REVISION RESPONSE LETTER

**RE: Veterans Victory (Apartments)
Site Development Plan
File Number: DEPN-23-0002**

DATE: March 1, 2023

DEVELOPMENT PLAN
PRELIMINARY UTILITY & PUBLIC FACILITIES PLAN

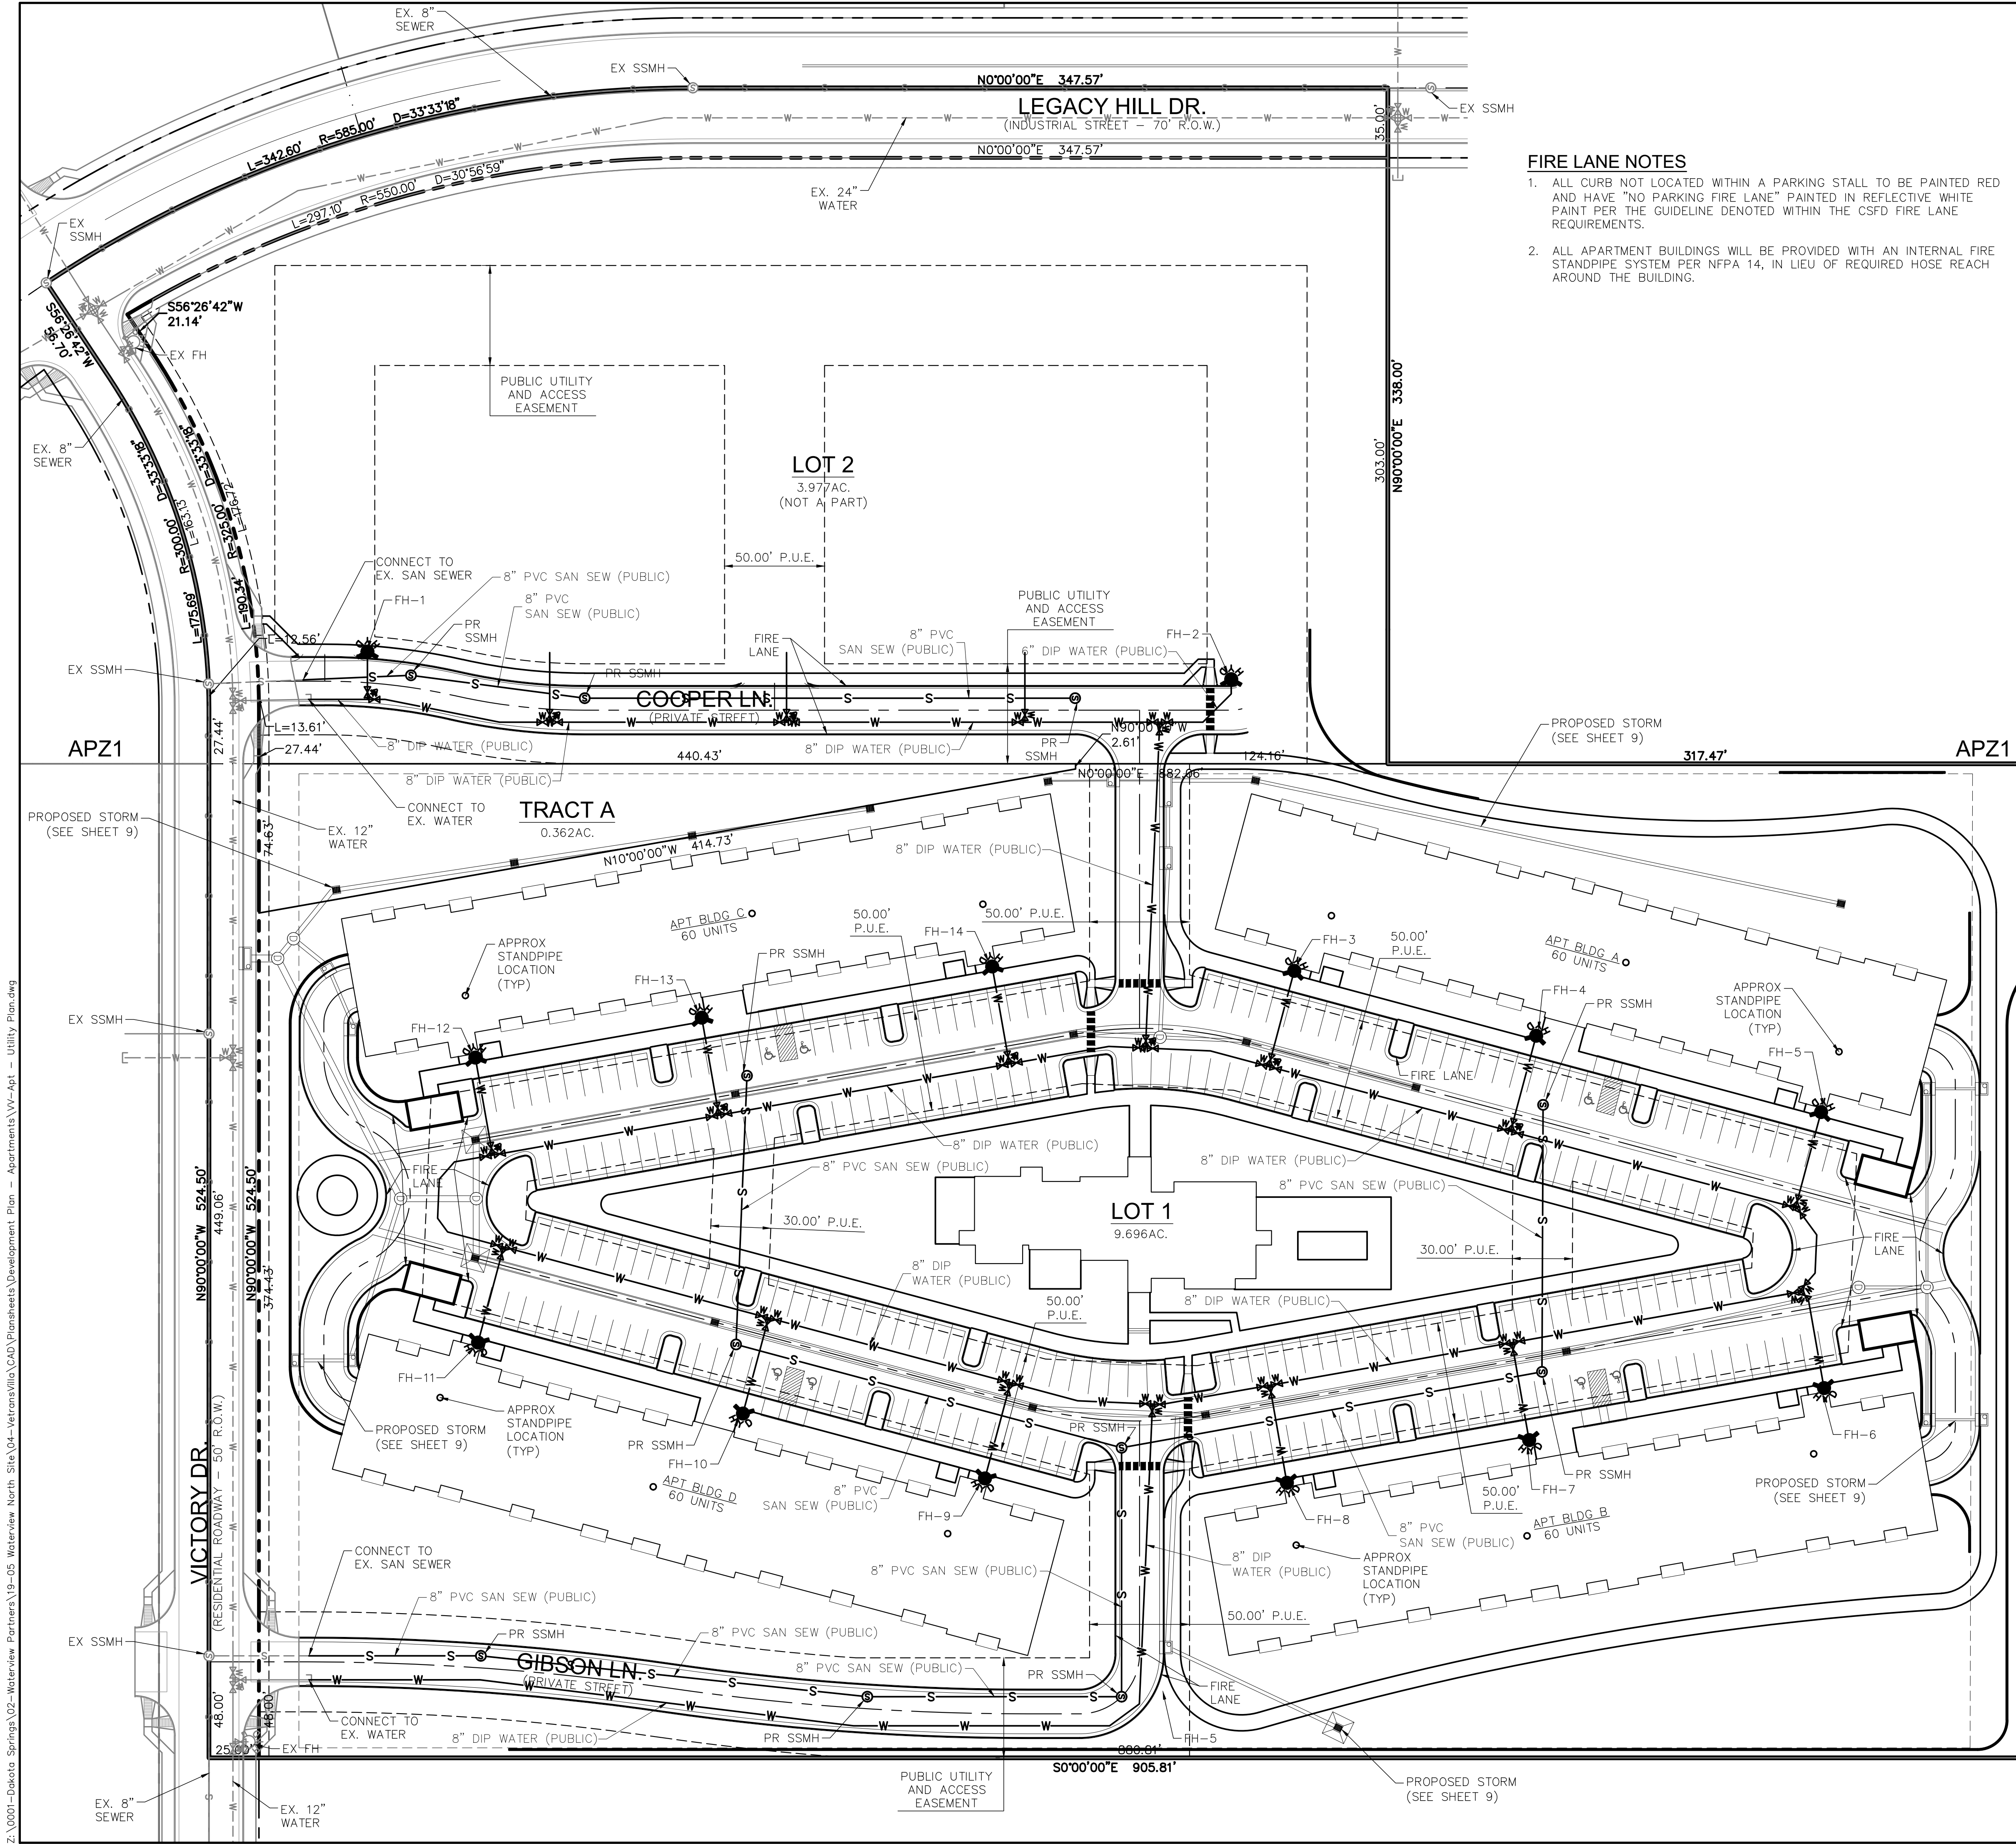
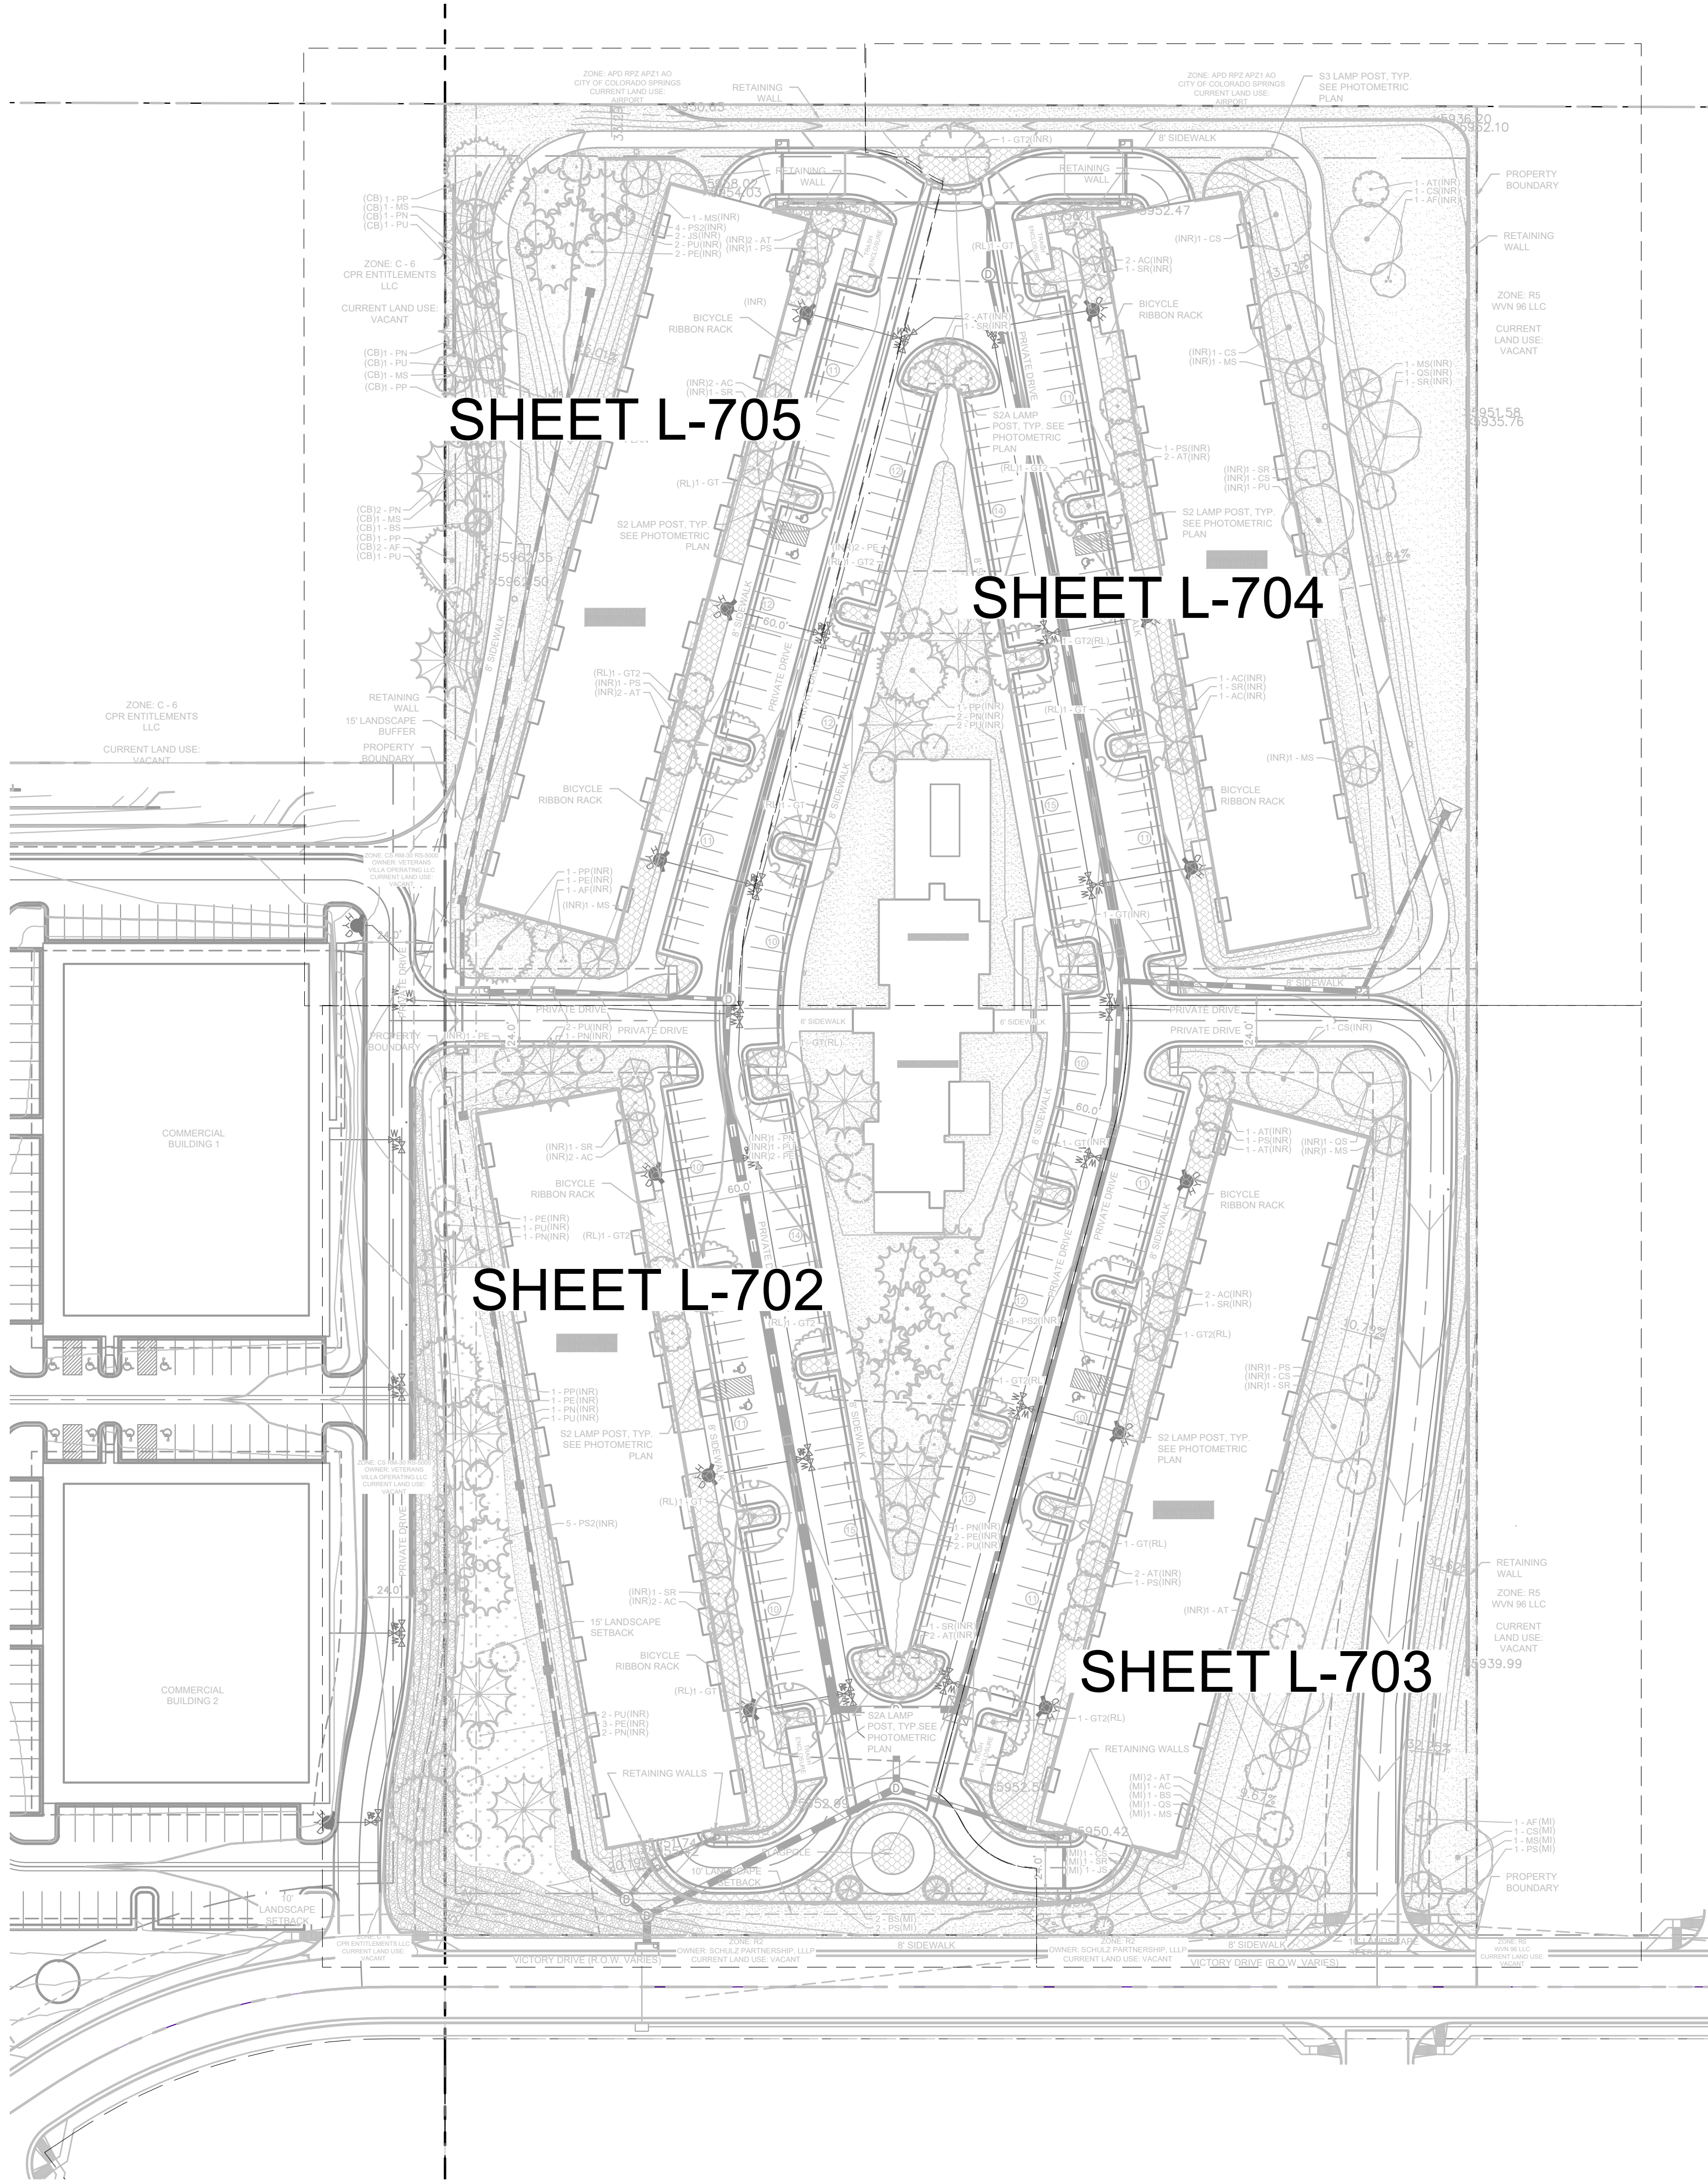
6. *Show the proposed location of the fire department connection (FDC) for each building. Coordinate this location with the landscape plans to ensure adequate access and visibility. Also ensure a fire hydrant is provided within 100' of each FDC. Standpipes and FDC locations shown on preliminary utility & public facility plan. Water system has been redesigned to locate fire hydrants within 100'-0" of each FDC.*

2. *Provide a note on the plans that indicates all apartment buildings will be provided with an internal fire standpipe system per NFPA 14, in lieu of required hose reach around the building.*
Note has been added to the utility sheet note 2 of “Fire Notes”

4. *Identify on the plans, all areas that will be marked as a fire lane. Leader callouts have been added to clarify Note 1 of “Fire Notes”*
5. *Remove this reference as this will not be permitted as a fire lane. Removed from plan.*
